CITY OF ALBUQUERQUE

September 11, 2025

**RE: Woodbury Apartments
Tr A Tracts A Thru M City Center, Phase 1, Mesa del Sol
Grading and Drainage Plan
Engineer's Stamp Date: 8/22/2025
Hydrology File: R16D097C**

SHEET NO.
C202

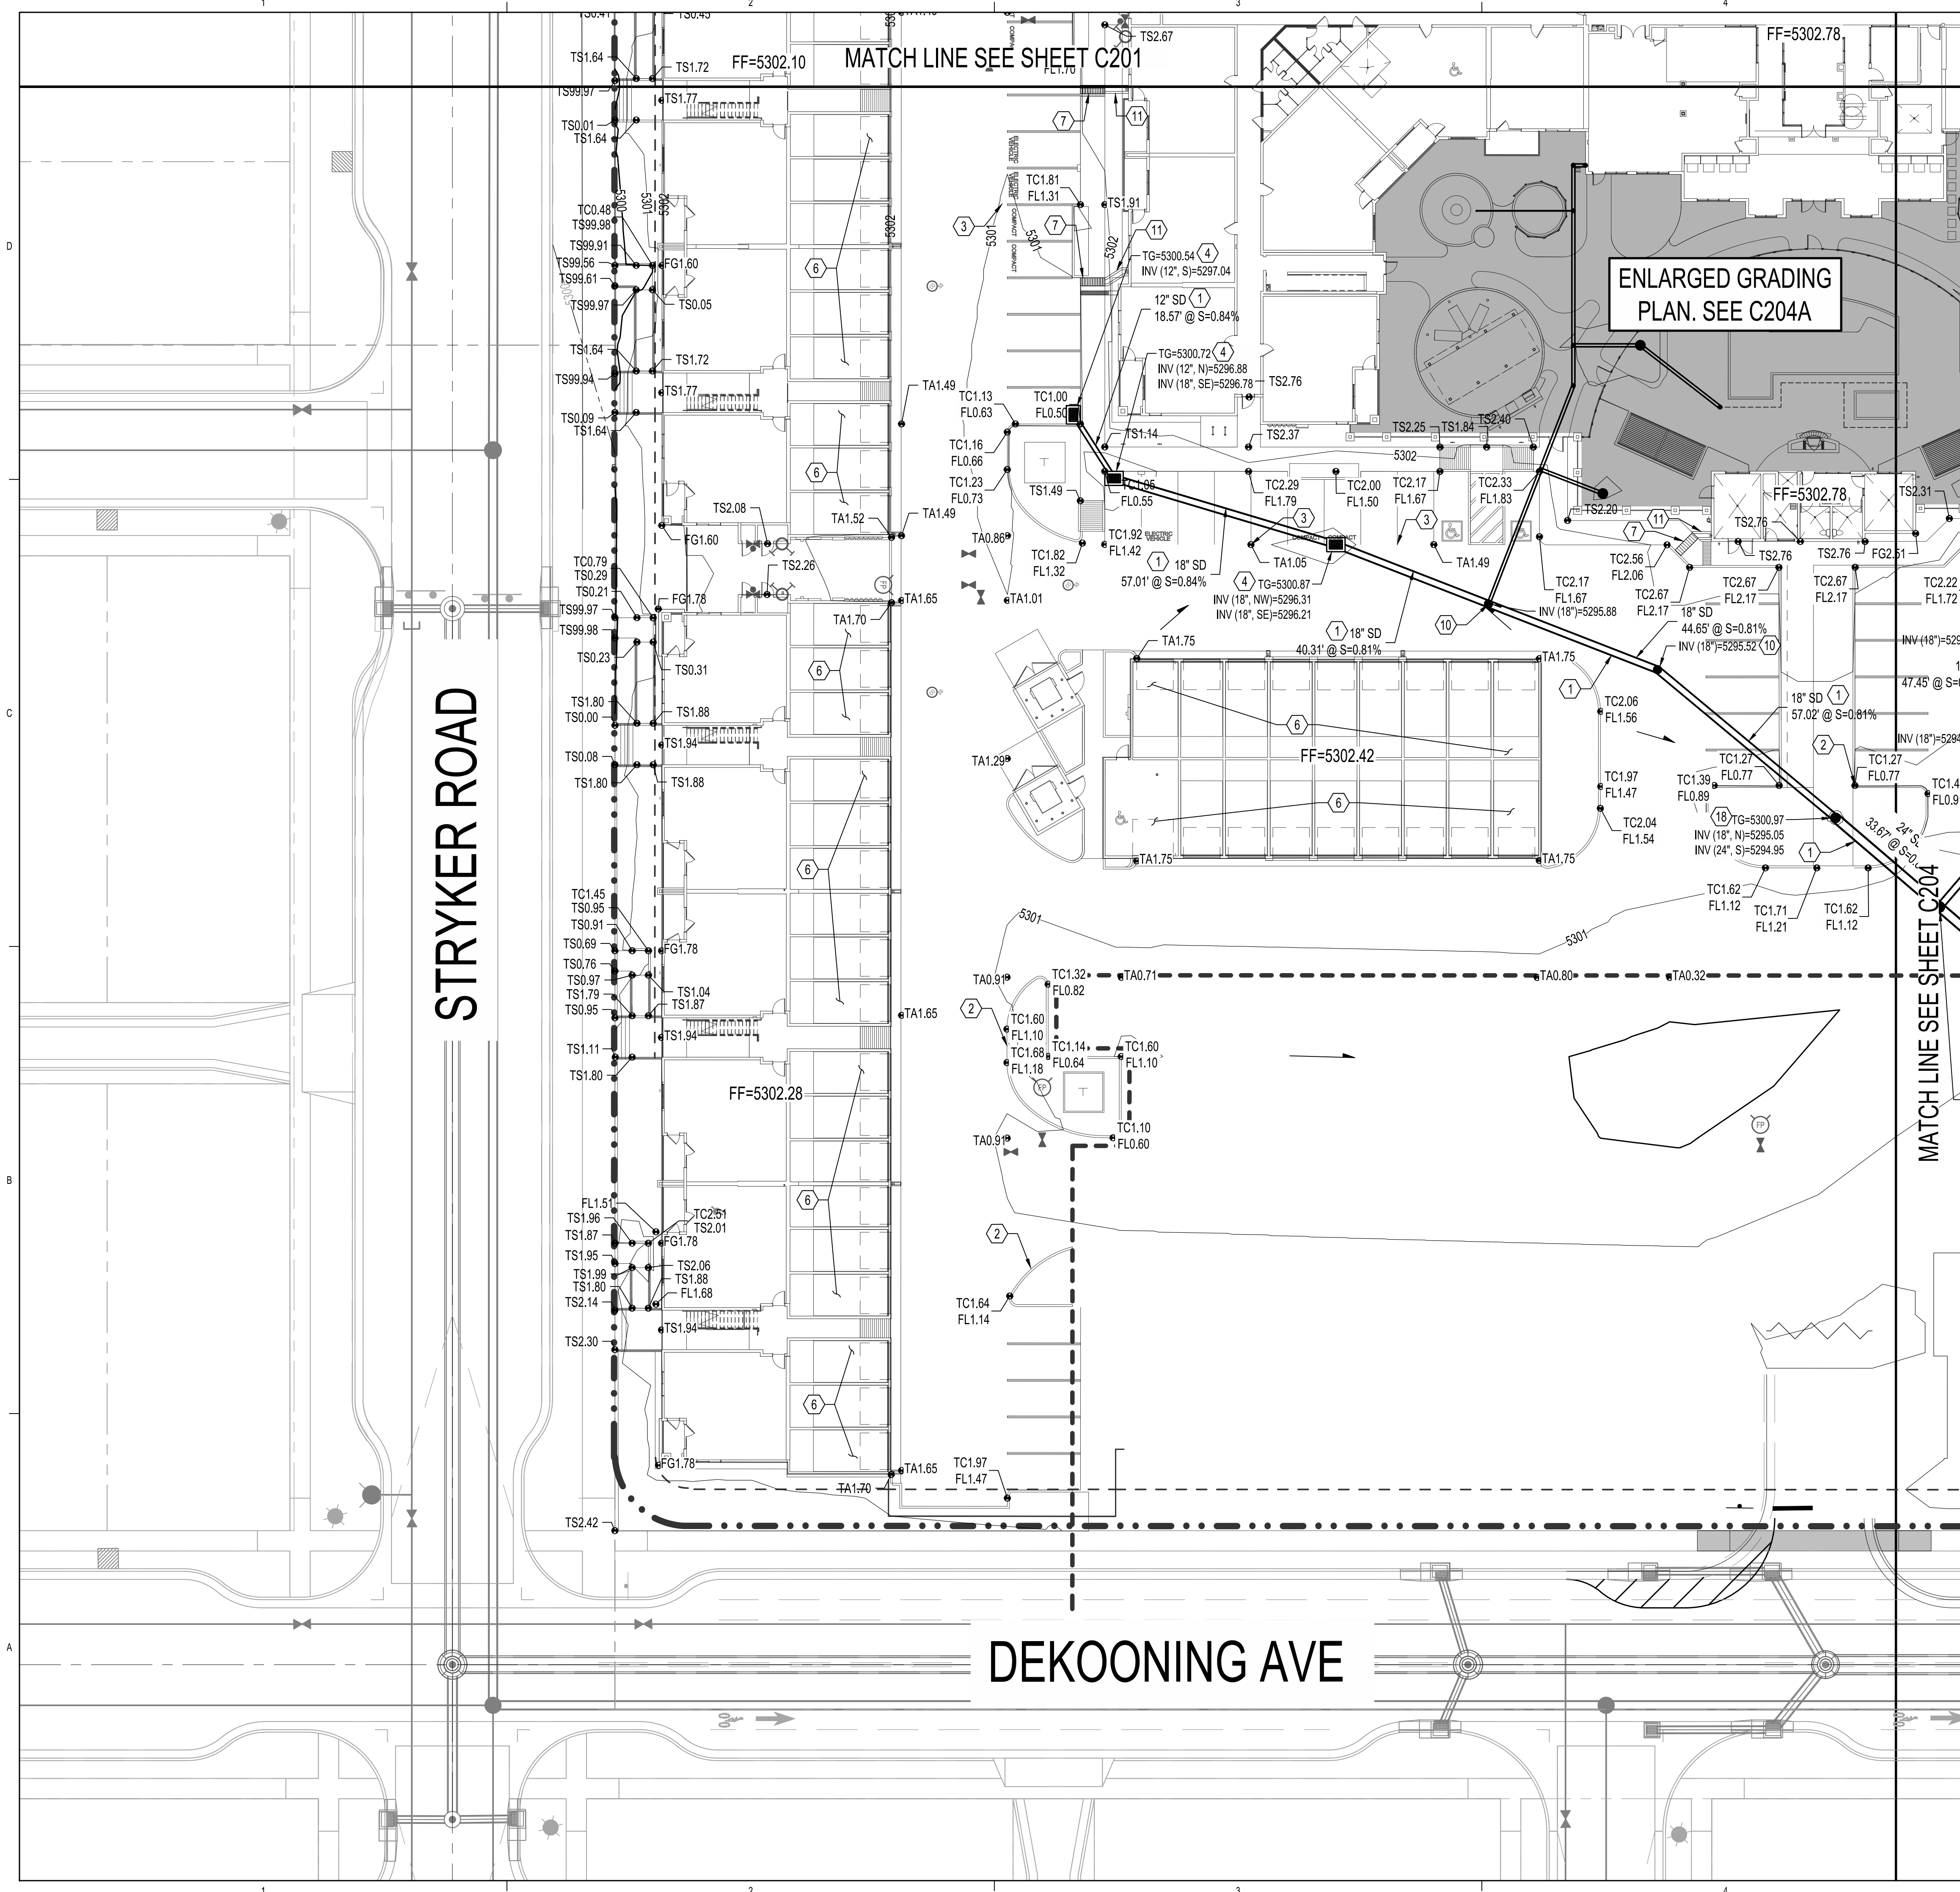
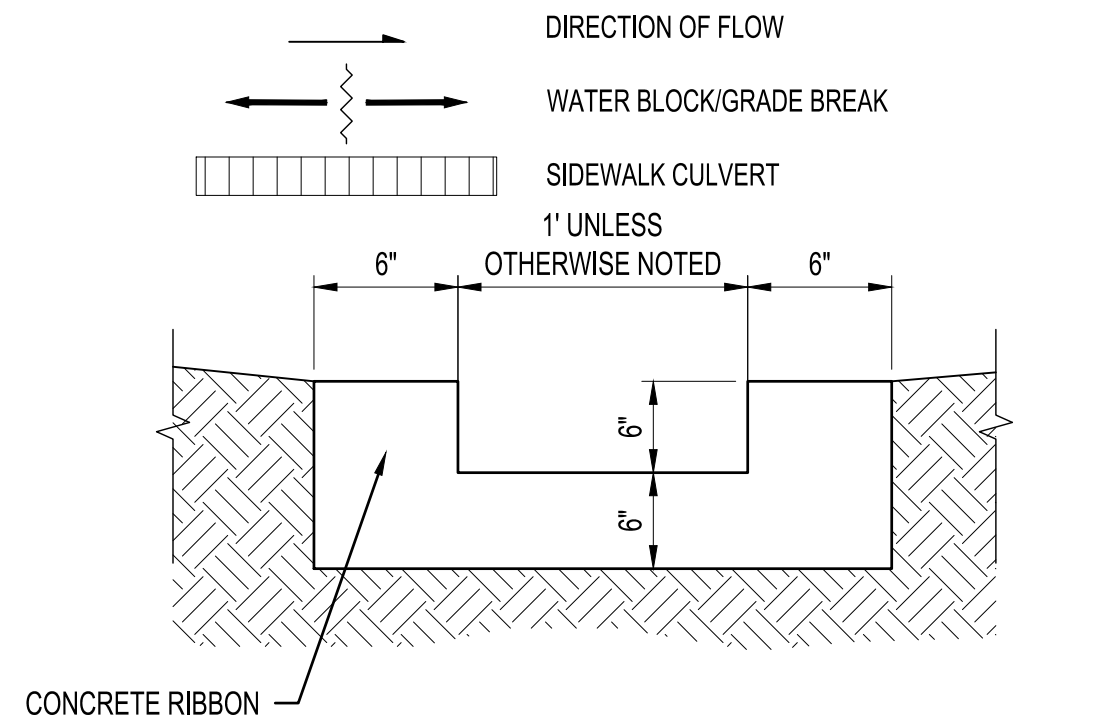
3. Sheet C202: Provide the concrete ribbon channel bottom thickness dimension.

SHEET NO.
C204

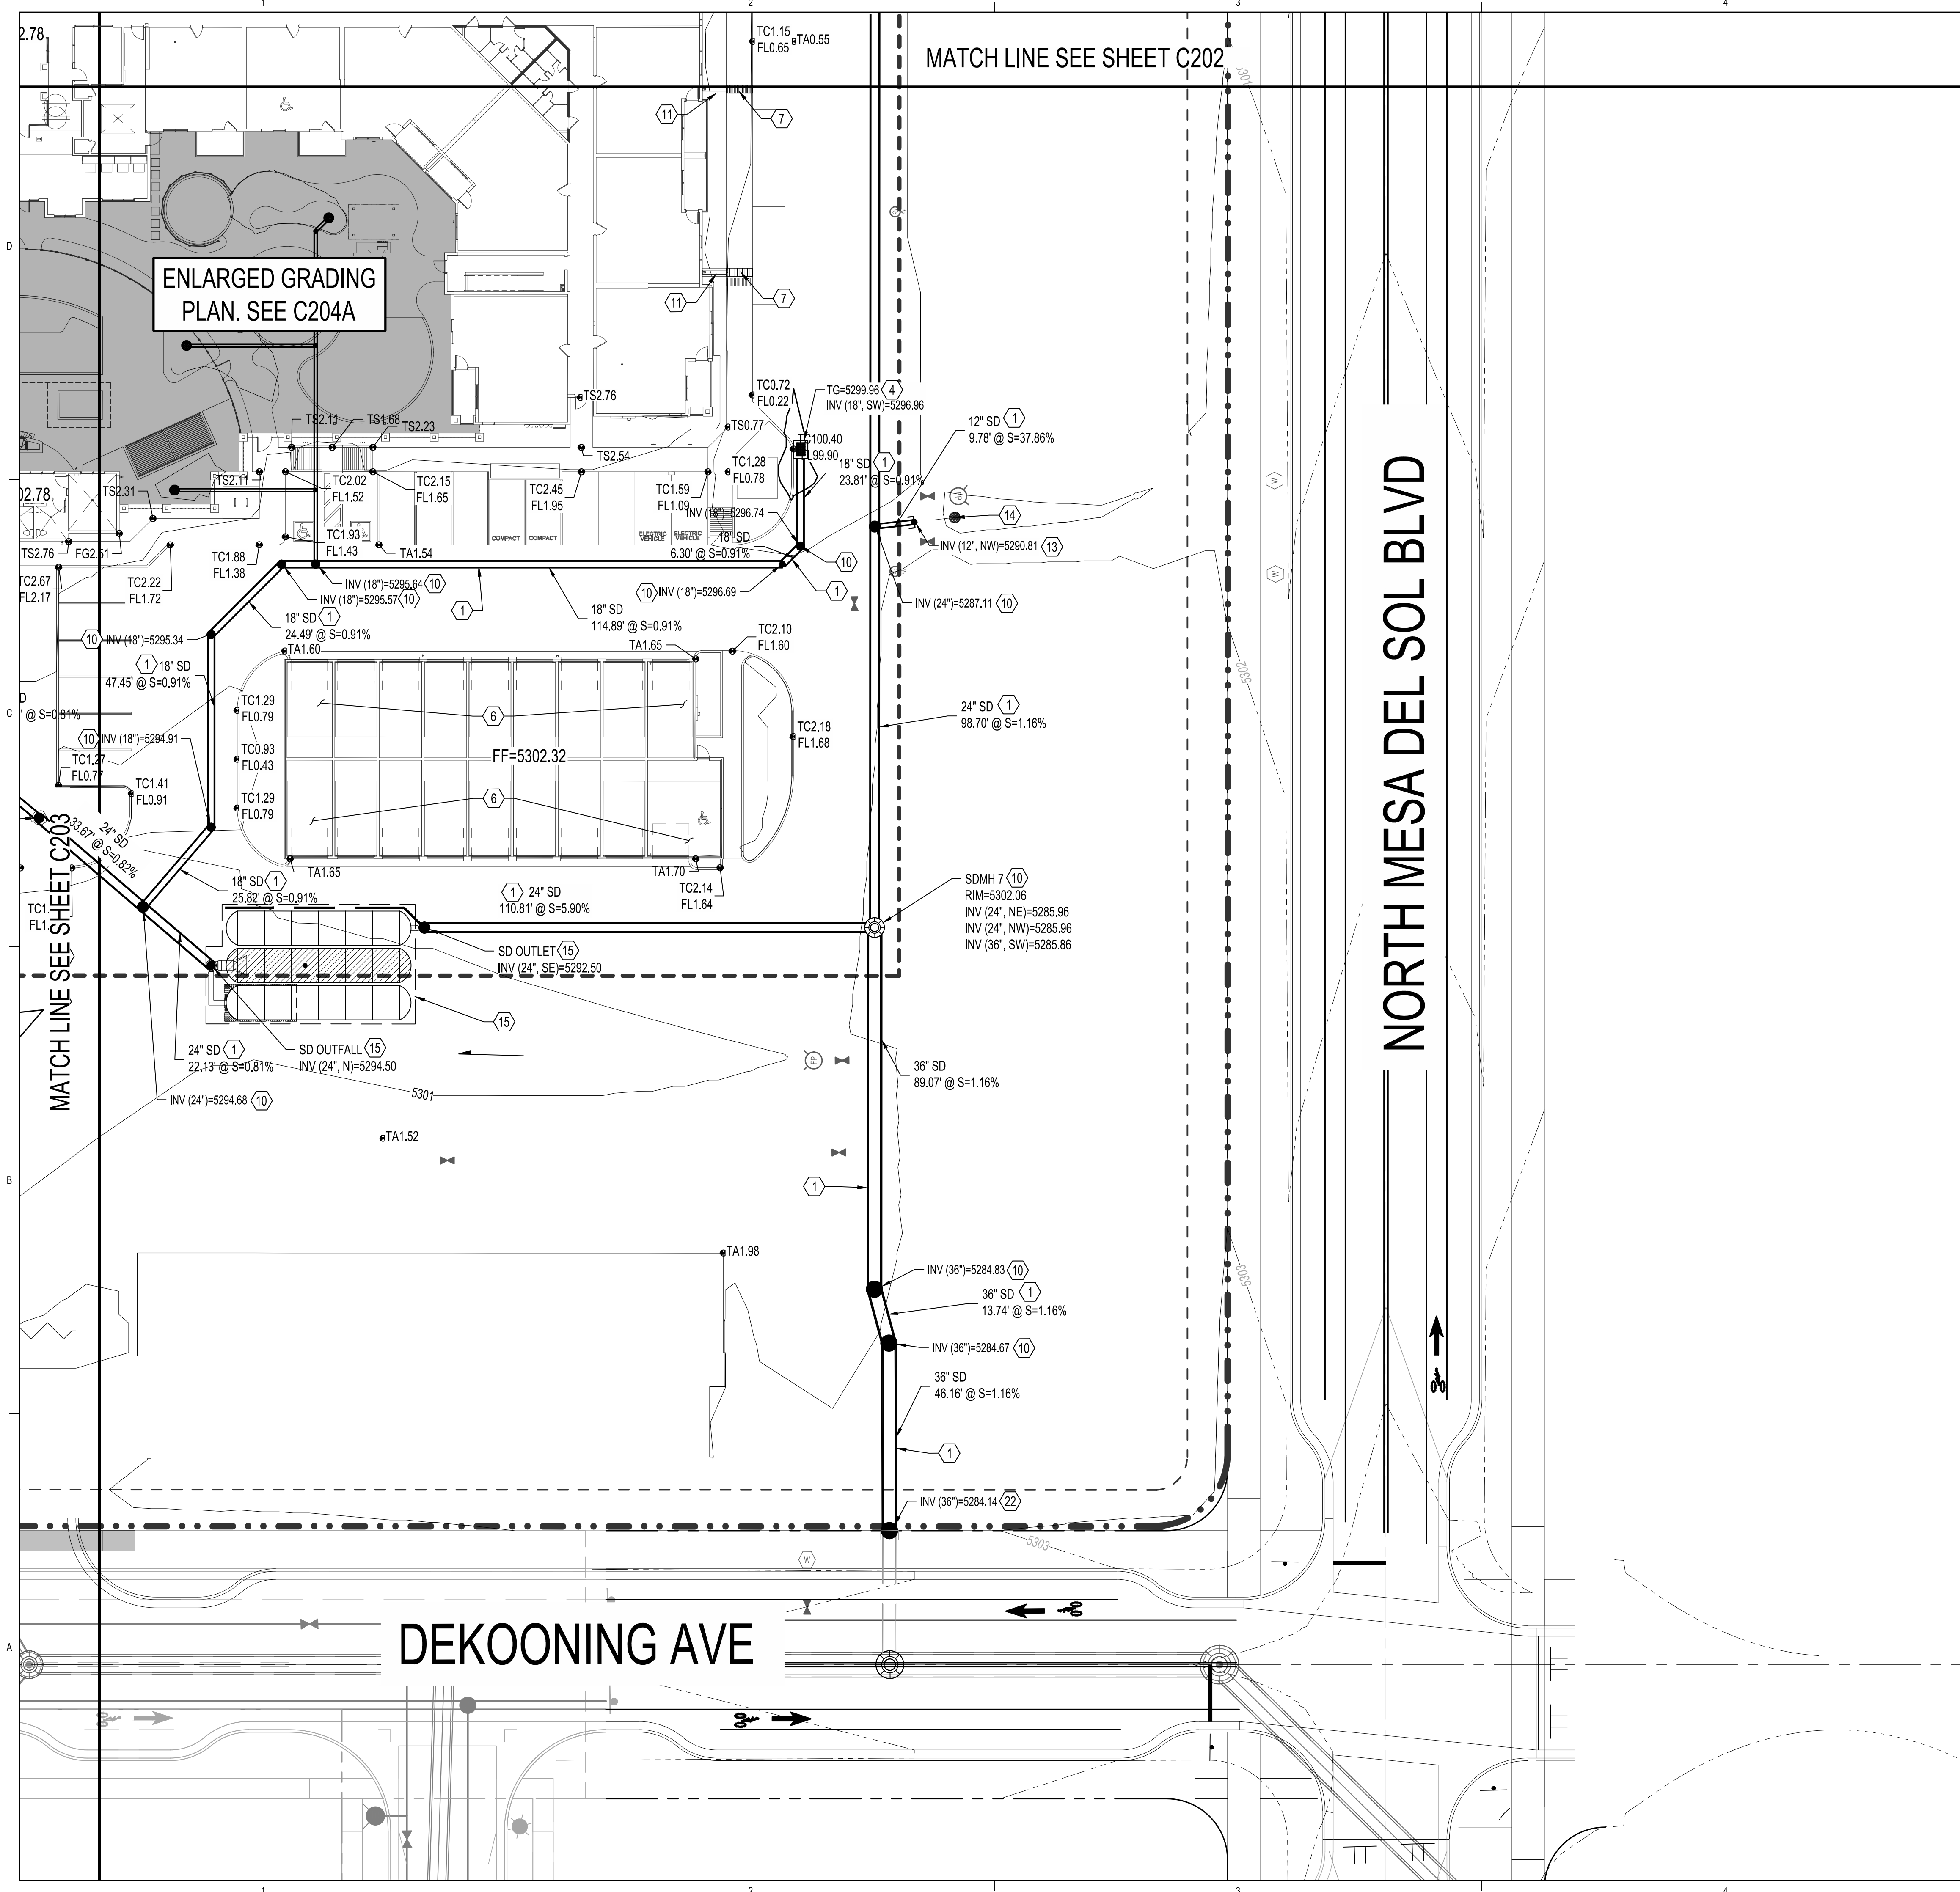
4. Sheet C204: Why is this proposed 36 SD line capped?
